**CITY OF ALBUQUERQUE  
PLANNING DEPARTMENT  
July 18, 2012  
DRB Comments**

**PROJECT # 1009333/1000482**

**APPLICATION # 12-70196**

**RE: Lots 1-20, La Vida Nueva Subdivision**

LA VIDA NUEVA SUBDIVISION
EXISTING SITE PLAN 1"=20'

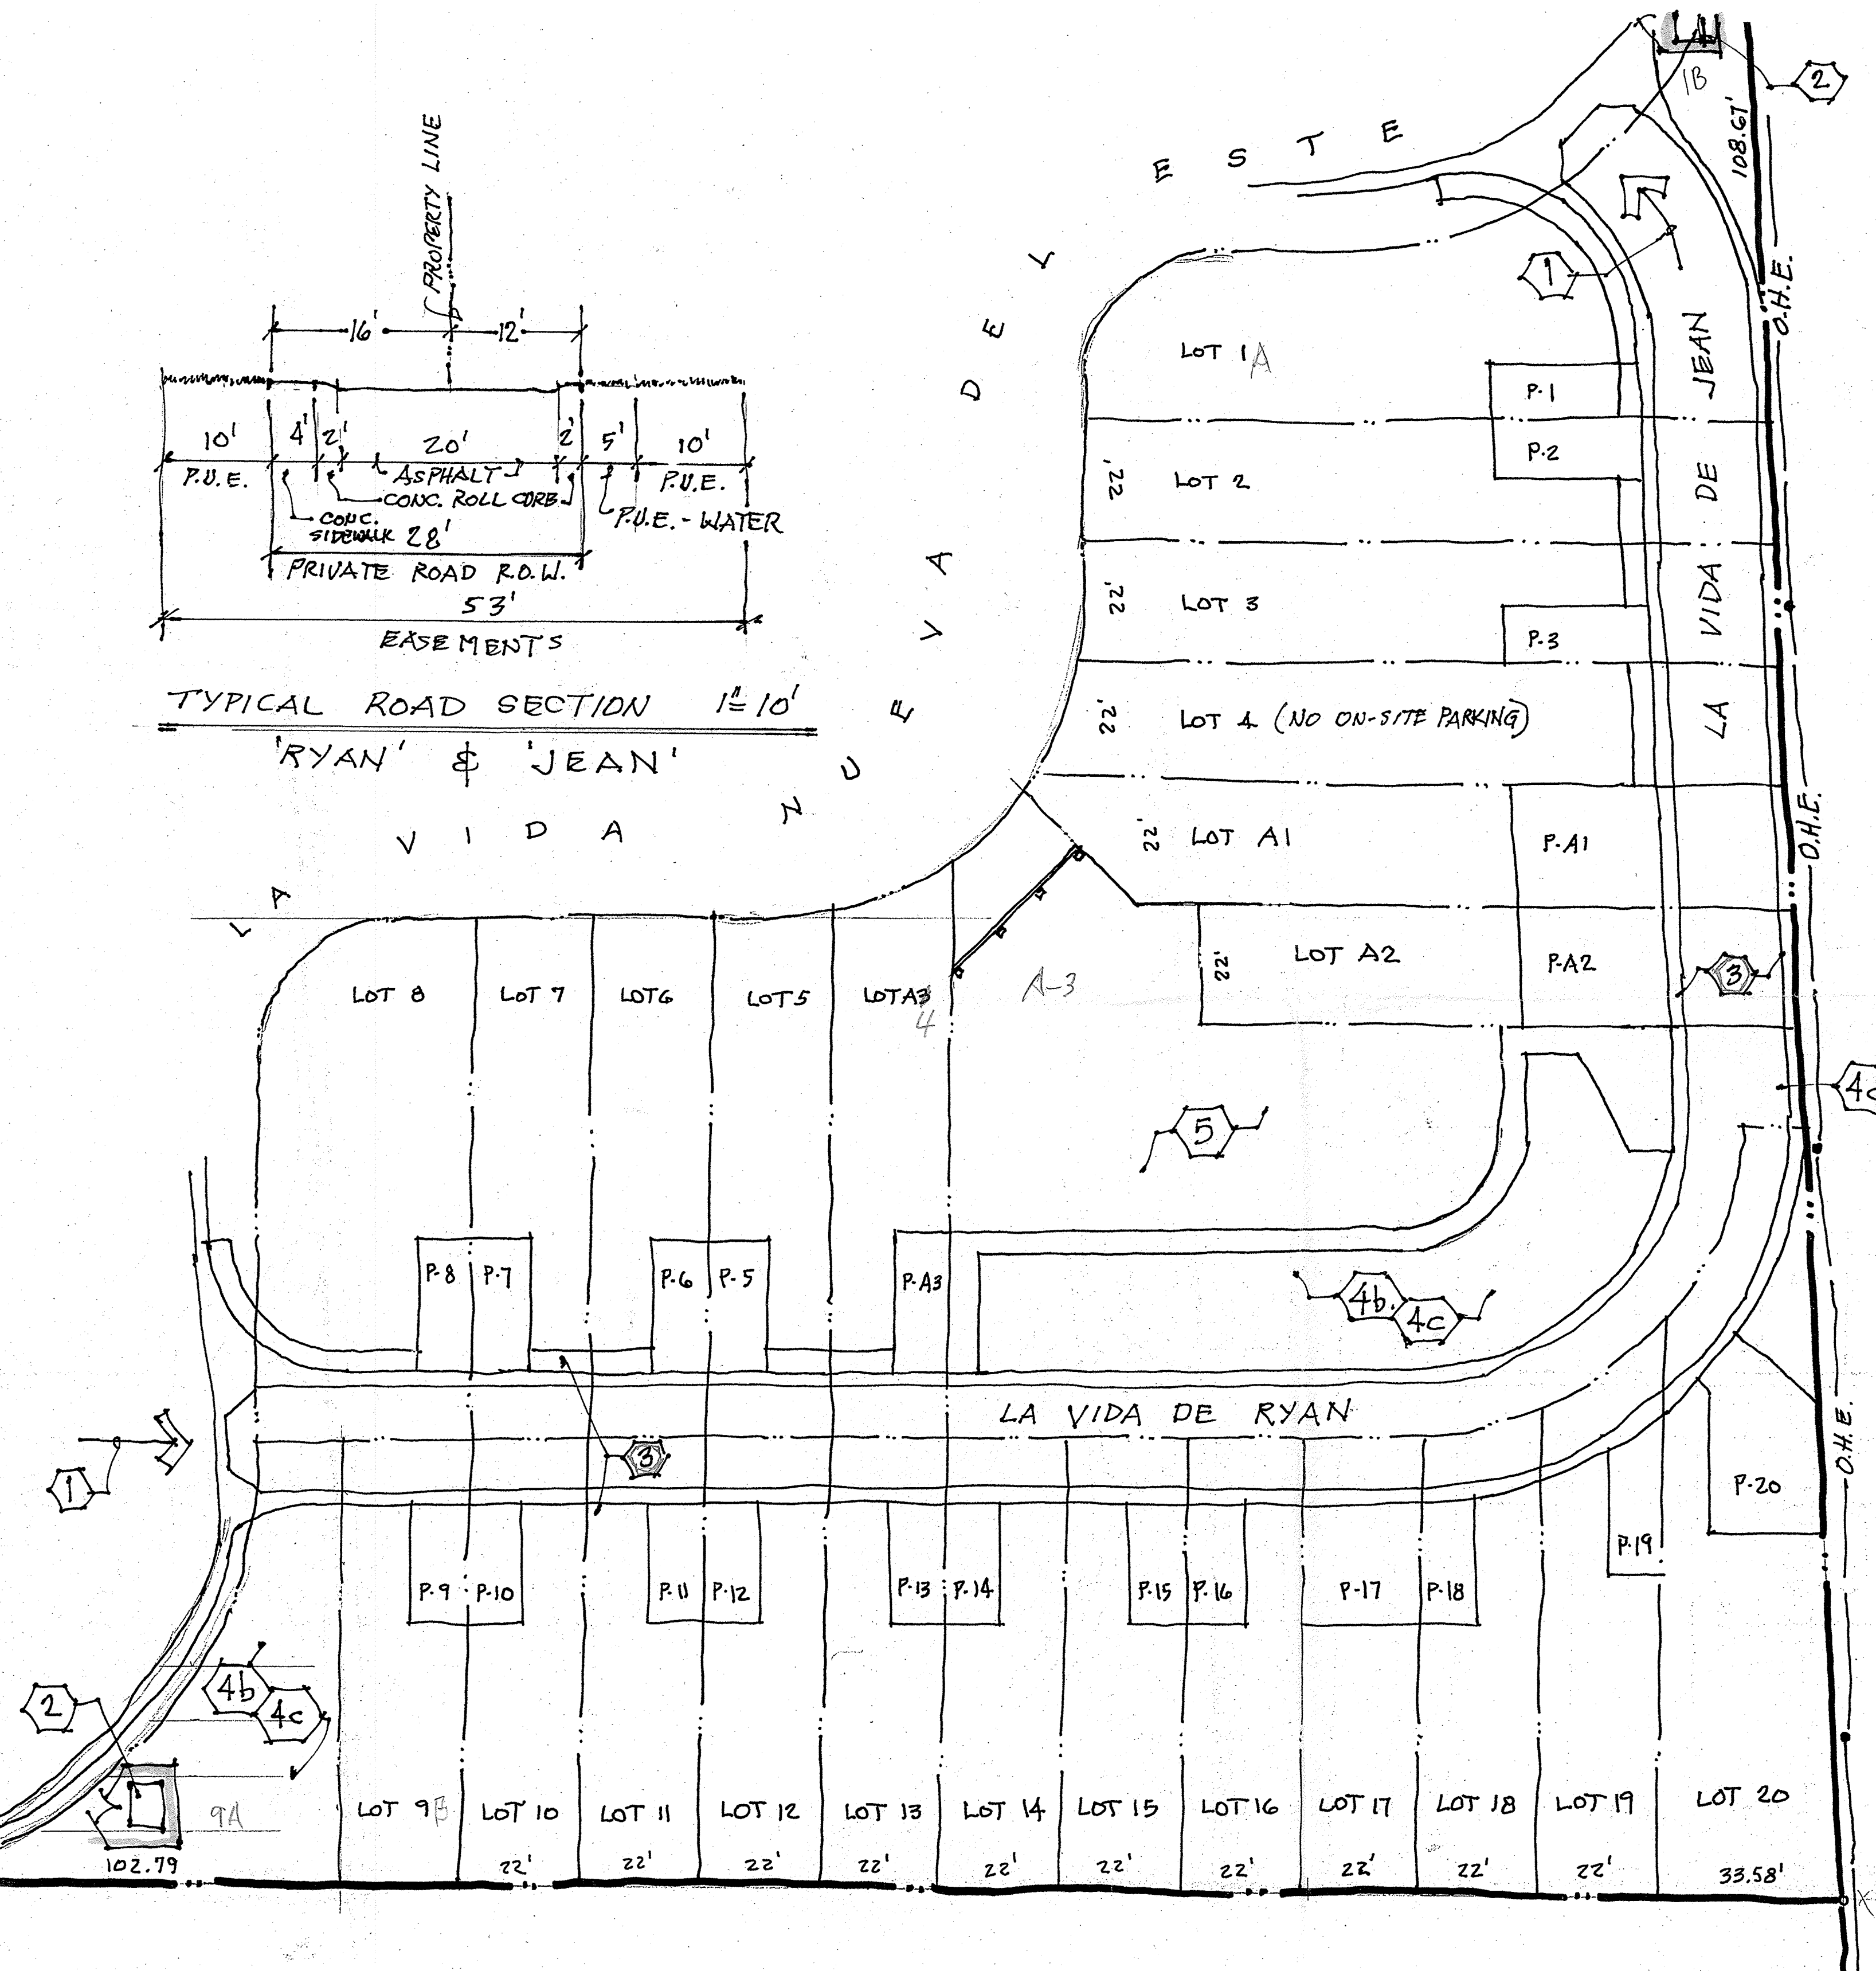
The existing private street(s) La Vida de Ryan and La Vida de Jean do not appear to meet the minimum standards for public right of way. Refer to comments from Transportation Development regarding the potential for reversing the one-way traffic flow and "No On-Street Parking" designations.

Enforcement of regulations on a private street will likely require a Homeowners' Association even for designation of a Fire Lane; again, refer to comments from Transportation Development.

Refer to comments from the Water Utility Authority (ABCWUA) regarding a water account for irrigation. Conversion of the Common Area to a garden area might require an amendment to the site development plan, but if so it should be able to be done administratively; contact Zoning Enforcement and the Current Planning Section.
